From: [Aaron Mostofi](#)
To: [Dusty Pilkington](#)
Subject: RE: VA-16-00001 Mostofi
Date: Wednesday, October 12, 2016 12:55:01 PM

RE: VA-16-00001 Mostofi

1. The CDS Building Division has no objection for the applicant to encroach into the setback. Distance to be determined by Planning Division.
2. Due to steep slopes on the property, full geo-tech and soils report is required as well

VA-16-00001

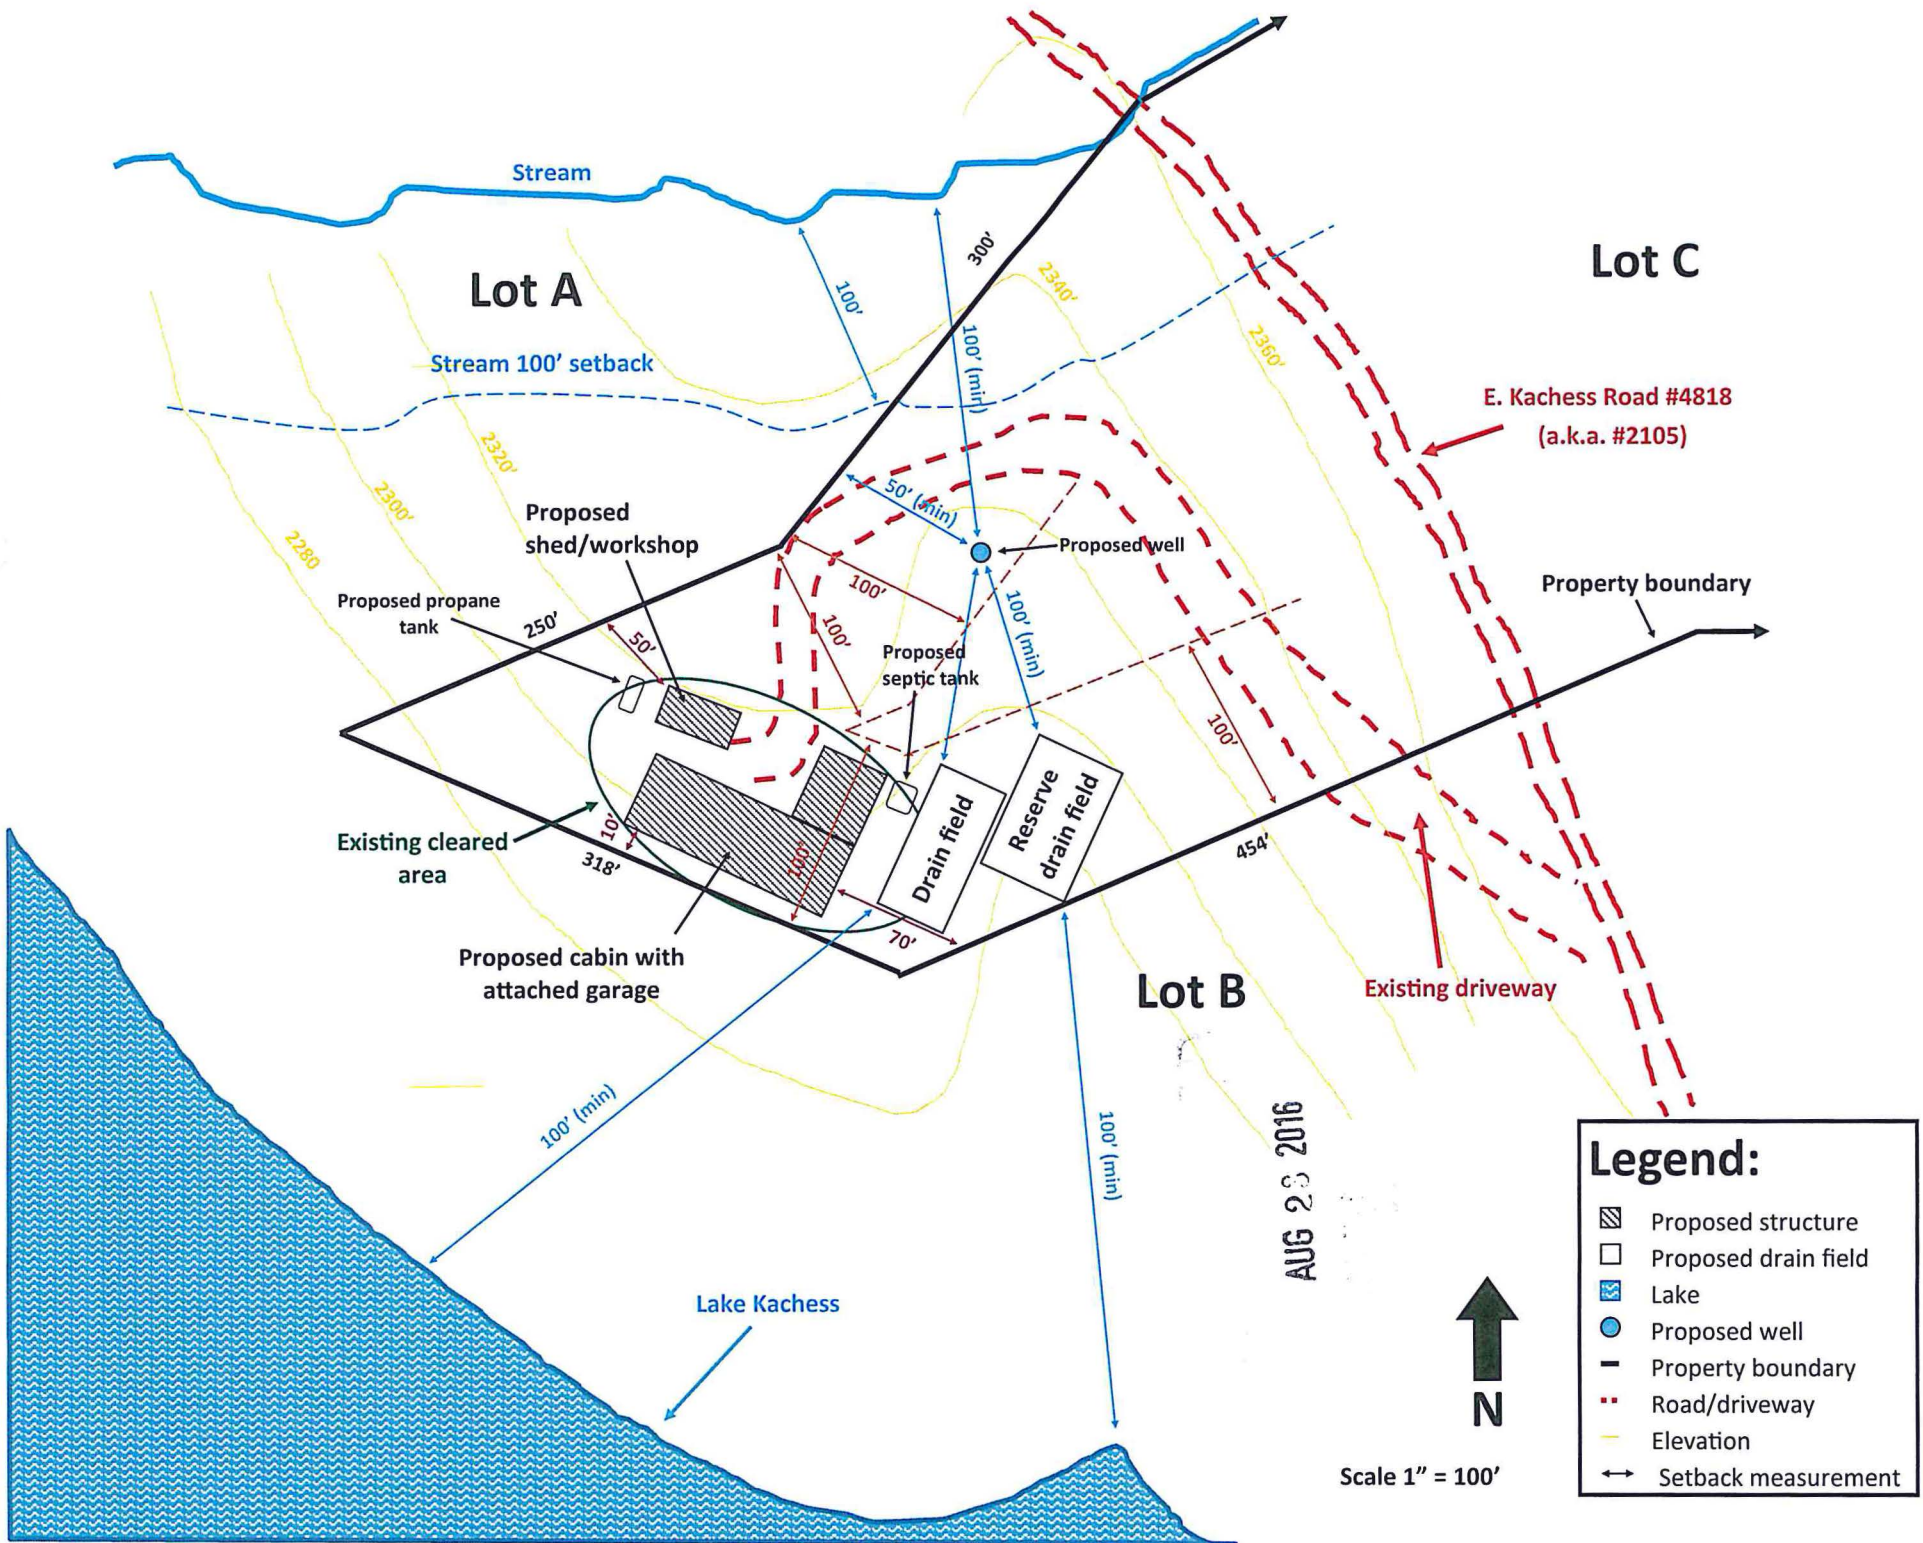
After looking at your site layout and the topo maps, nearest I can tell, you may very well be building outside the steep slope area of your property. Our GIS mapping may not be entirely accurate so we like to error on the side of caution.

If you supply a good cross section of the property and proposed building foundation (similar to the attached picture) we could make the determination that you do or do not meet these requirements. If however our inspectors on site for the first footing inspection determine otherwise, if perhaps the building were moved or shifted too close to a setback, geo-tech could still be required.

I don't think I've seen a better method of mapping out the slope and providing us the exact dimensions as this.

I have shared this with our office and this more than suffices for proof of meeting slope and setbacks to slopes.

No additional information is required regarding setbacks to slopes.
